REF: 22/01144/F

Location: OS Parcel 5700 South West Of Grange Farm

Holding objection

25 May 2022

Drawing Name:  
ENHANCED - Phase 1 & 2 - Gatehouse

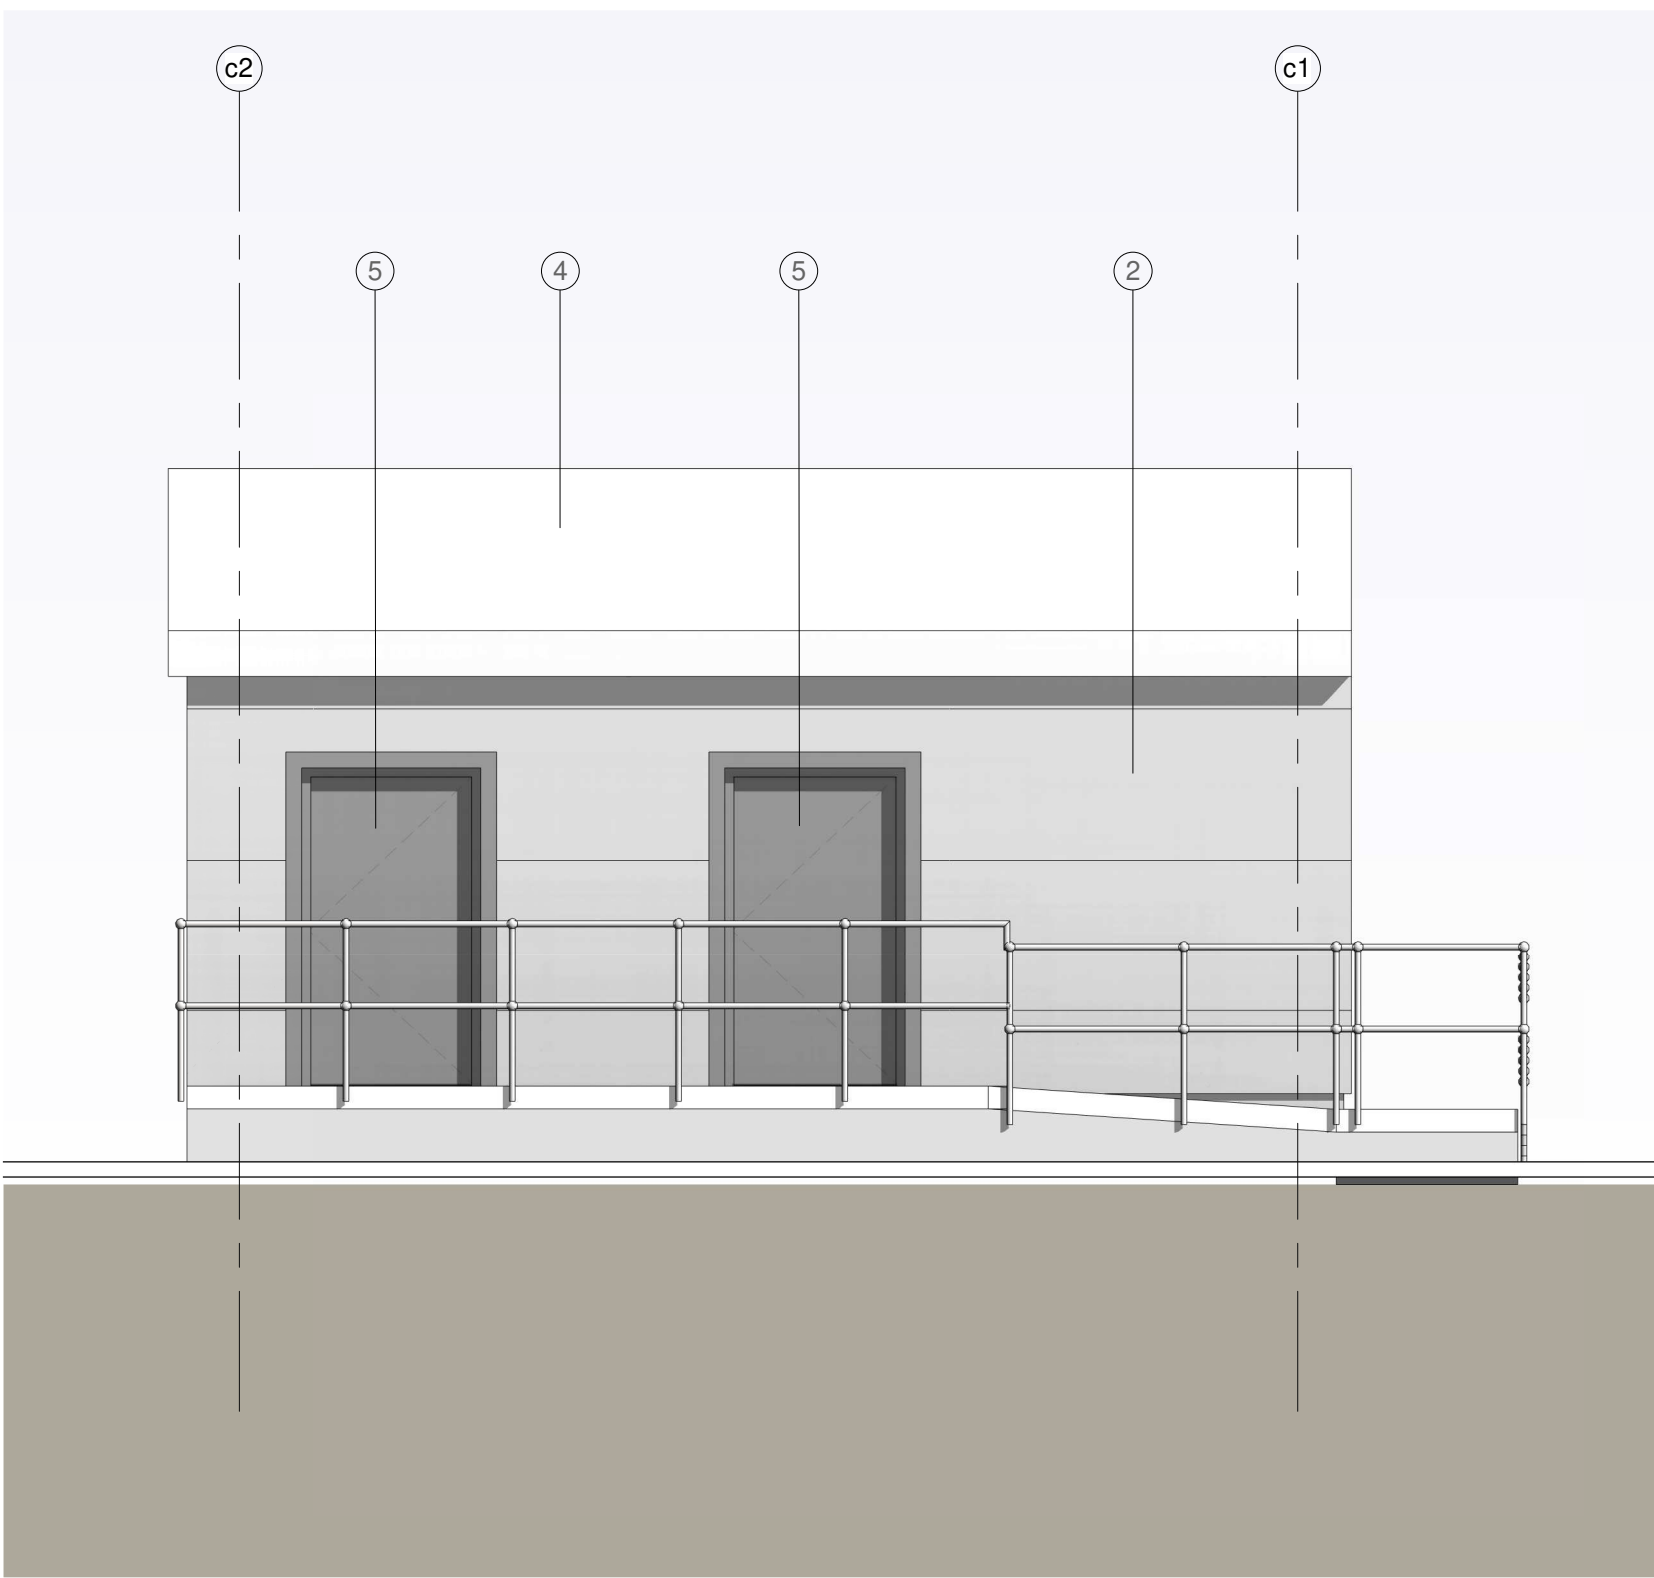
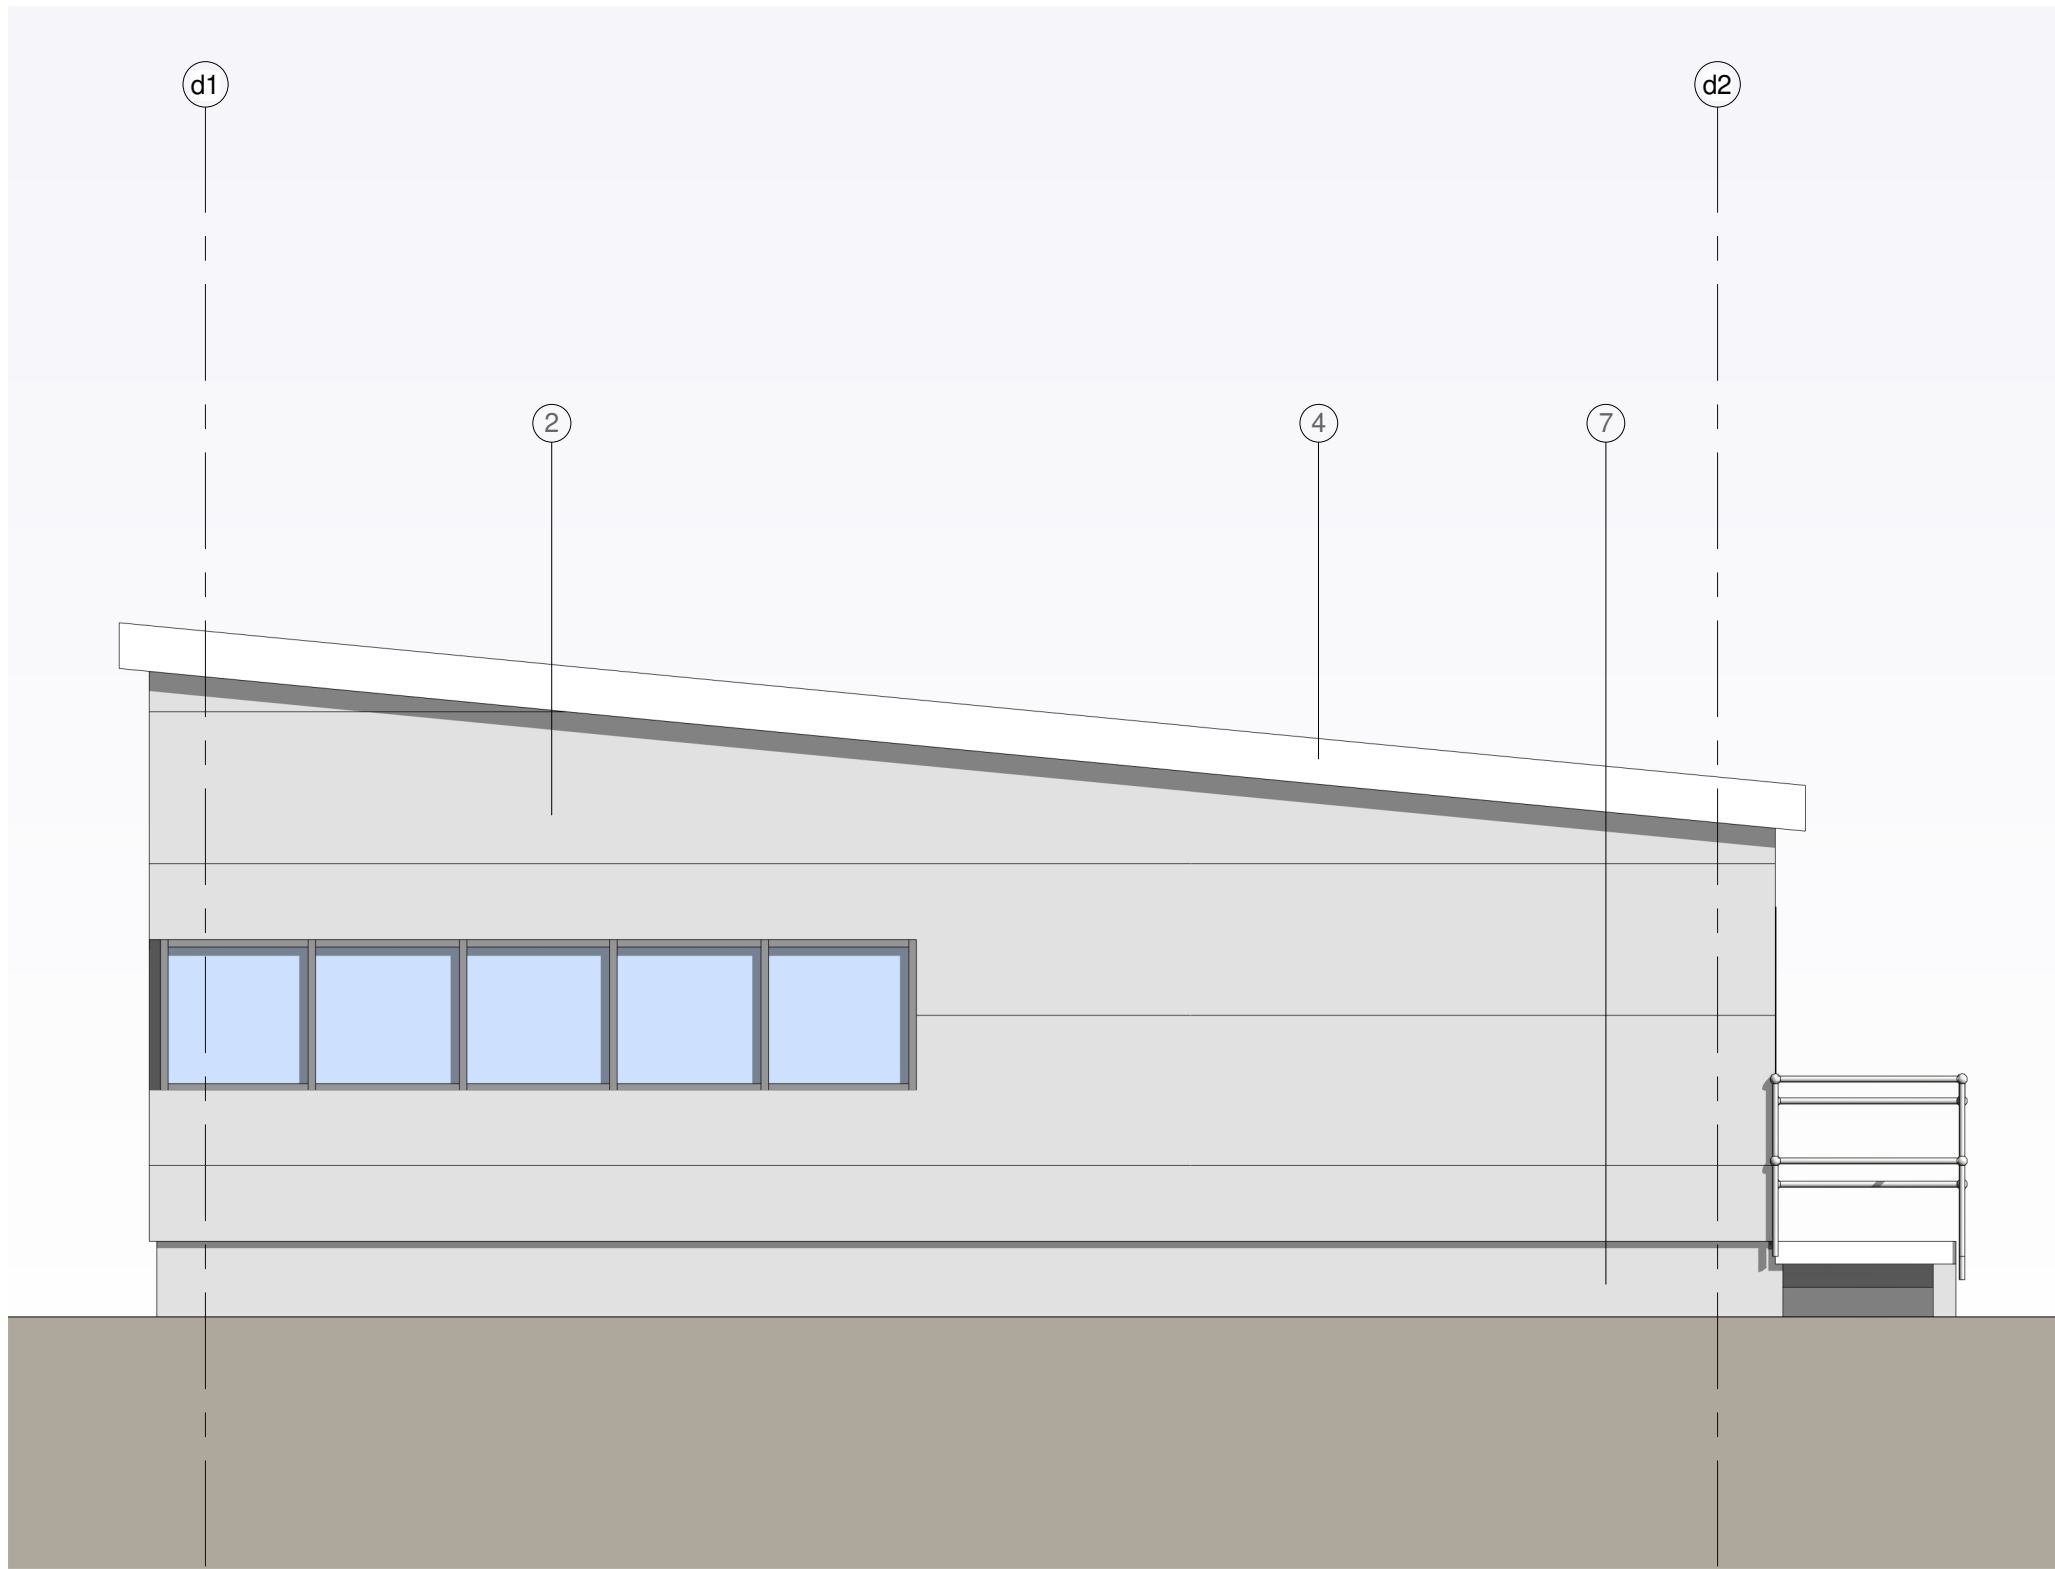
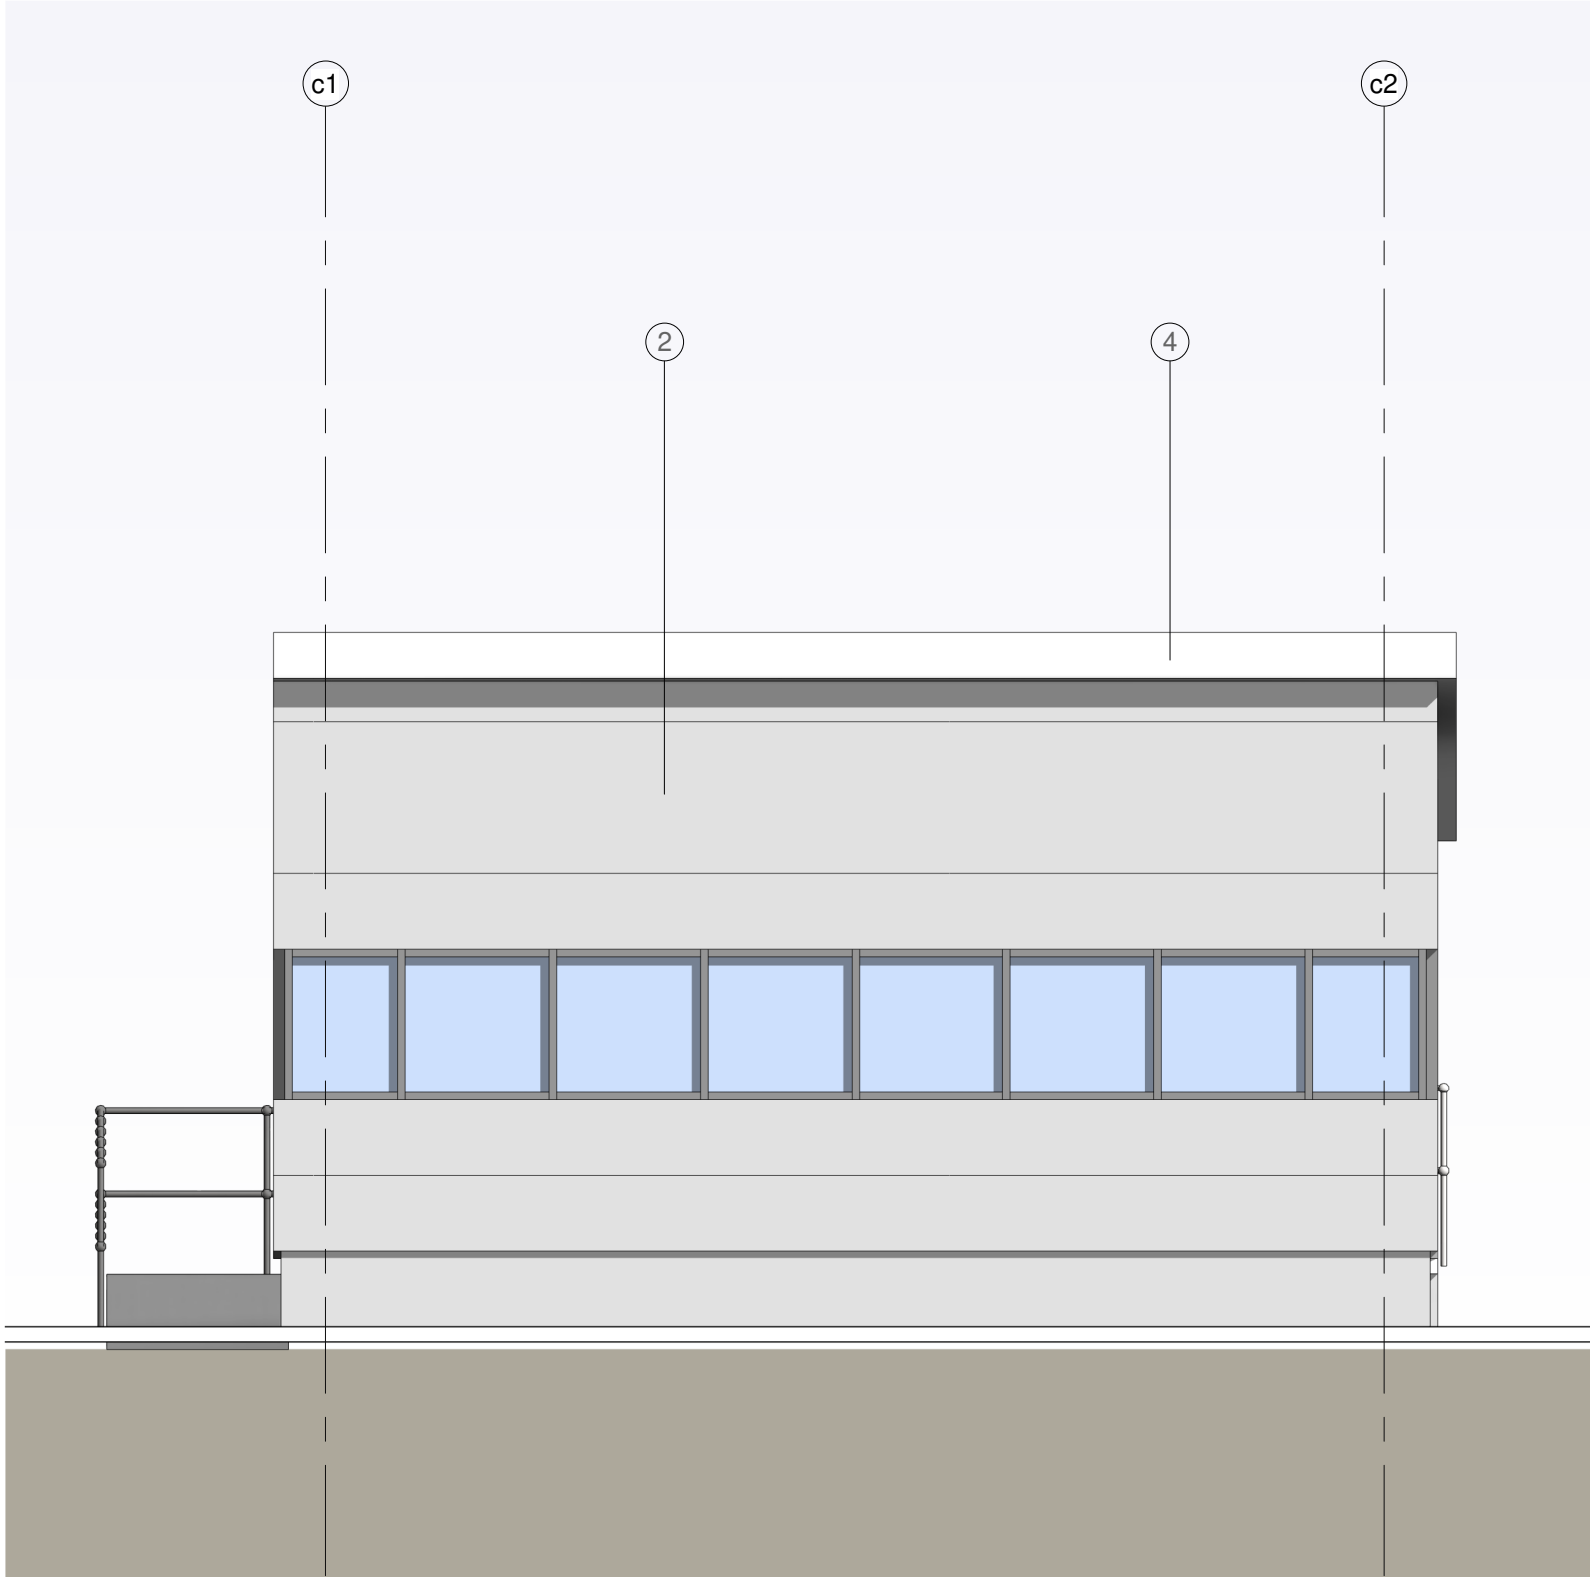
- I recommend the entry point to the site for vehicles and pedestrians is located alongside the gatehouse to provide additional surveillance and security over vehicular and pedestrian movements to and from the site.
- Formal surveillance (CCTV) should be provided and must be designed holistically in conjunction with lighting and landscaping to avoid areas of pooling or shadowing of light which could compromise the effectiveness of the system. CCTV installations should be certificated to the requirements of BS EN 50132-7: 2012+A1:2013. An operational requirements study should be completed to inform the location and specification of cameras around the site, and details should be submitted to the LPA and approved in writing before occupation and use of the building.
